Re: Design Evaluation
Maedge Residence
4687 NC HWY27, Lillington, NC
Project # 20-1240

As authorized, McClancy Engineering, PC performed a limited evaluation of the ongoing construction at the above site. The evaluation was performed and this report written by Mr. John McClancy, P.E., president of McClancy Engineering.

As we understand it, the purpose of our assignment was to evaluate certain code compliance issues that had been raised by the local code official having jurisdiction. As requested, our services are limited to performing a partial inspection, involving only these issues.

SANTA BARBARA AMERICAN TRADITION / CUSTOM FOUNDATION PLAN

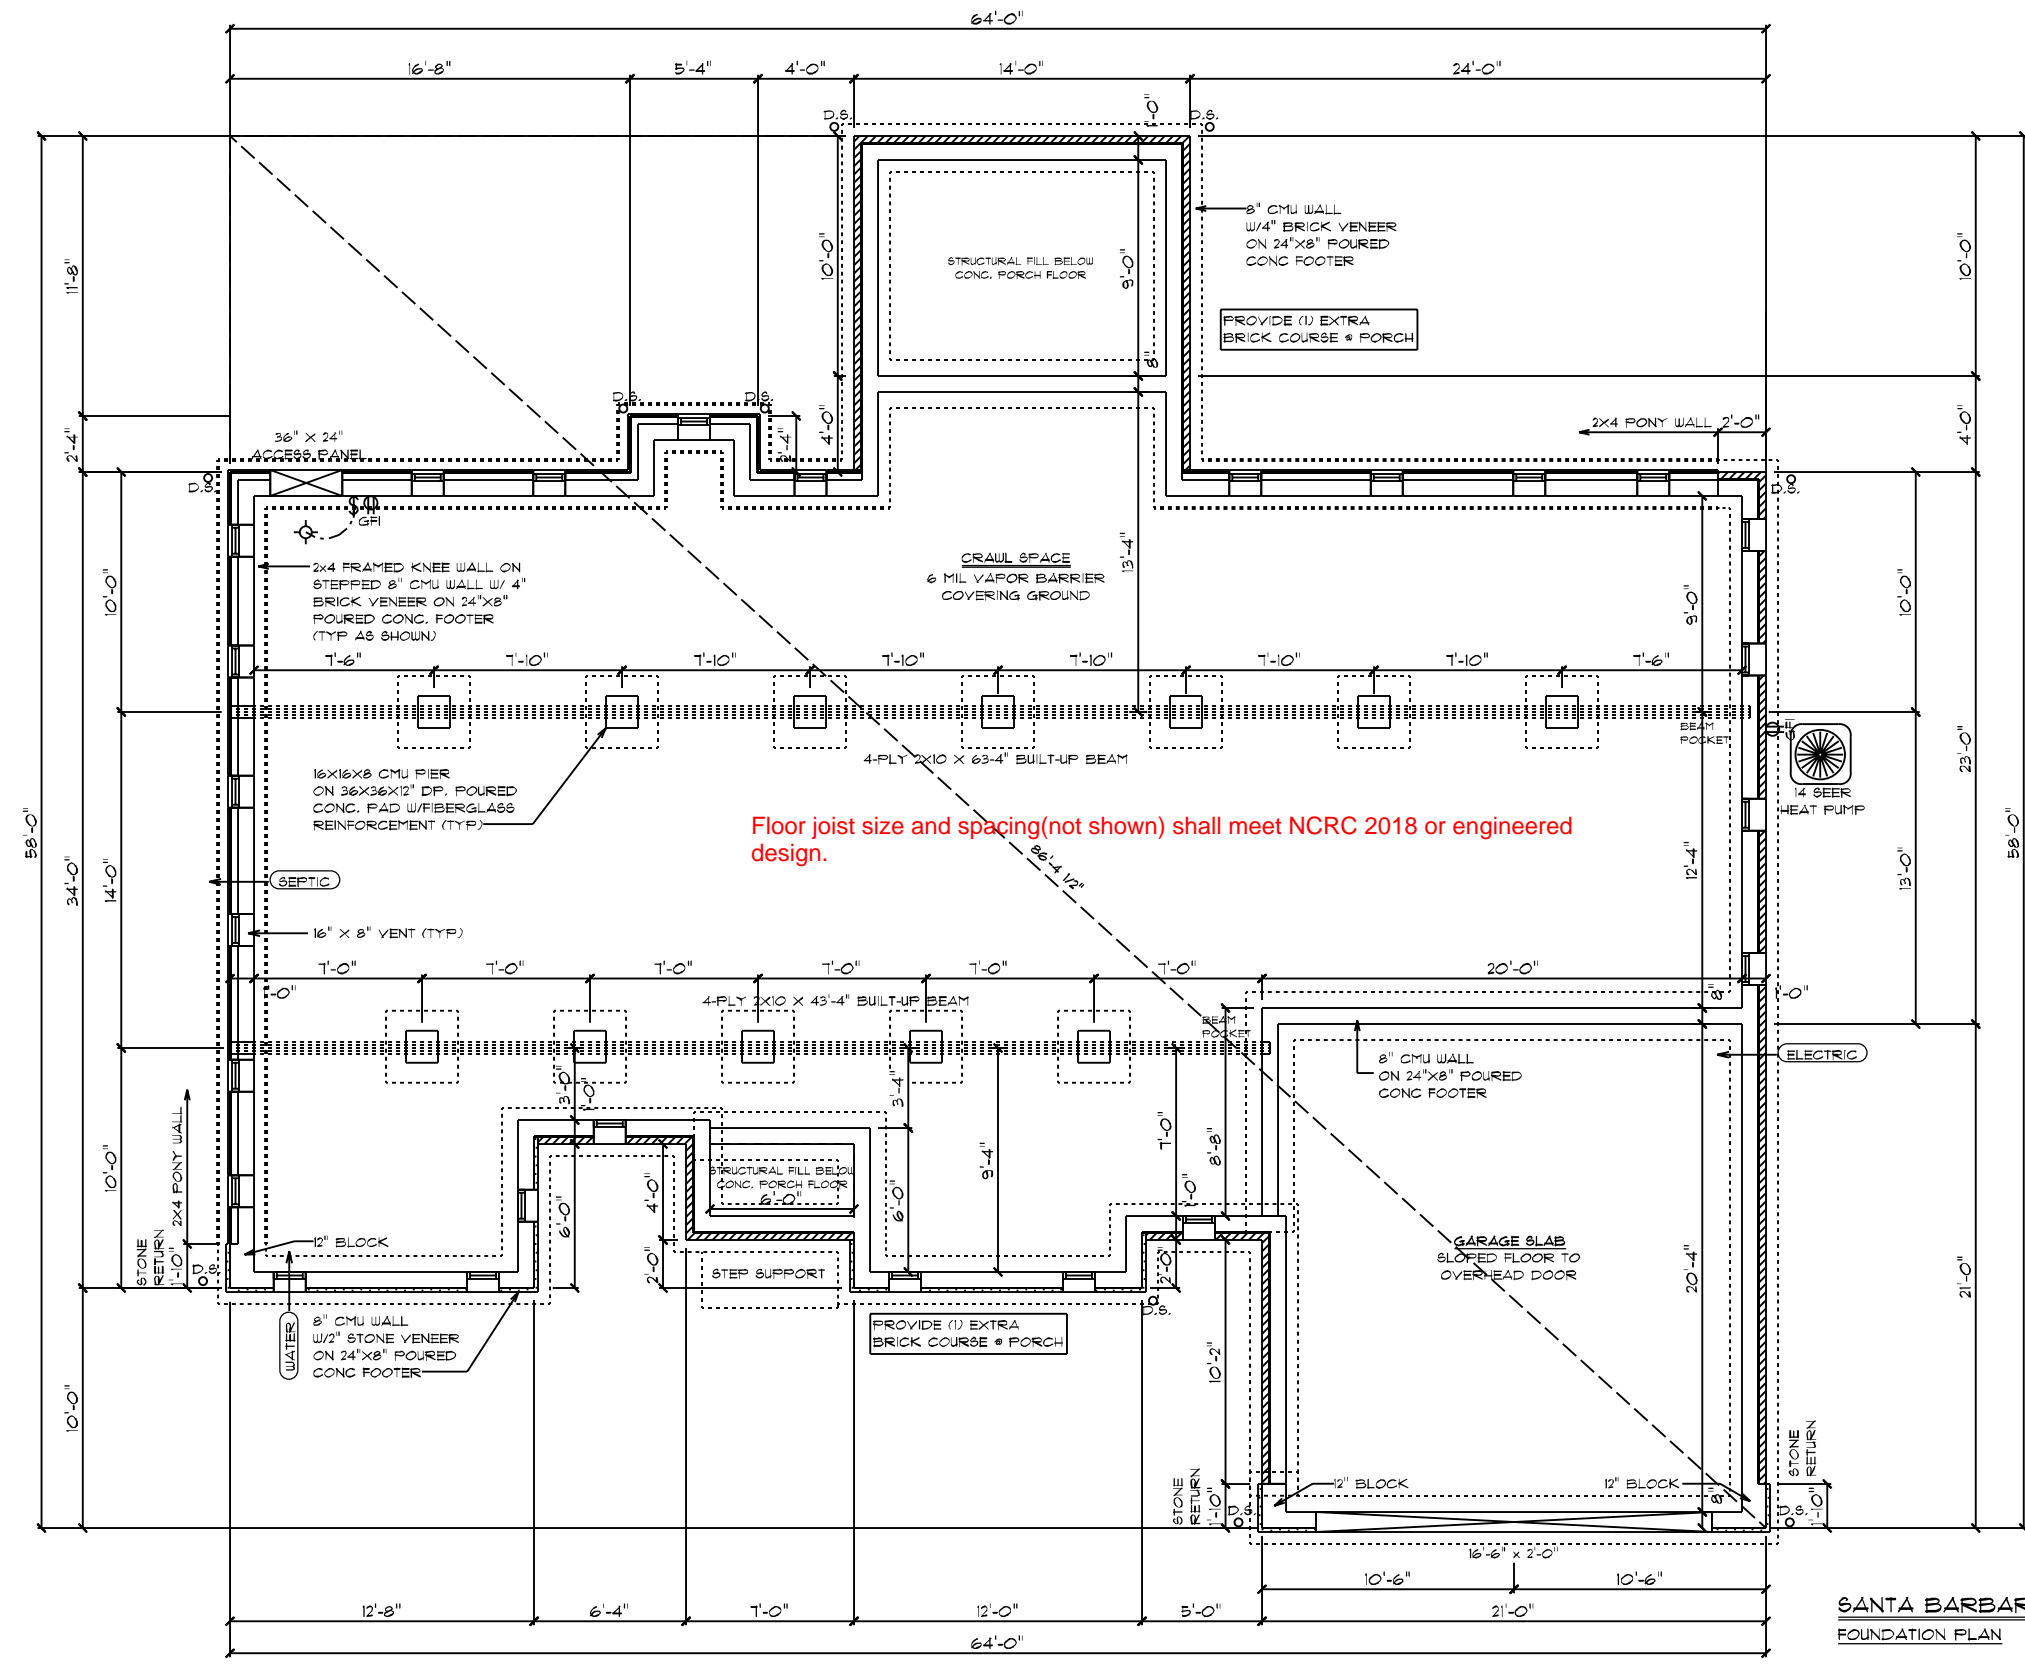
1. Evaluate the depth of the stone fill below the porch slabs.

The void below front and rear porch slabs was completely enclosed by minimum 8" thick masonry stem walls approximately 48 inches tall. The voids were filled with #57 clean crushed stone to a depth of approximately 44 inches.

The as-built condition was adequate to support the porch slabs.
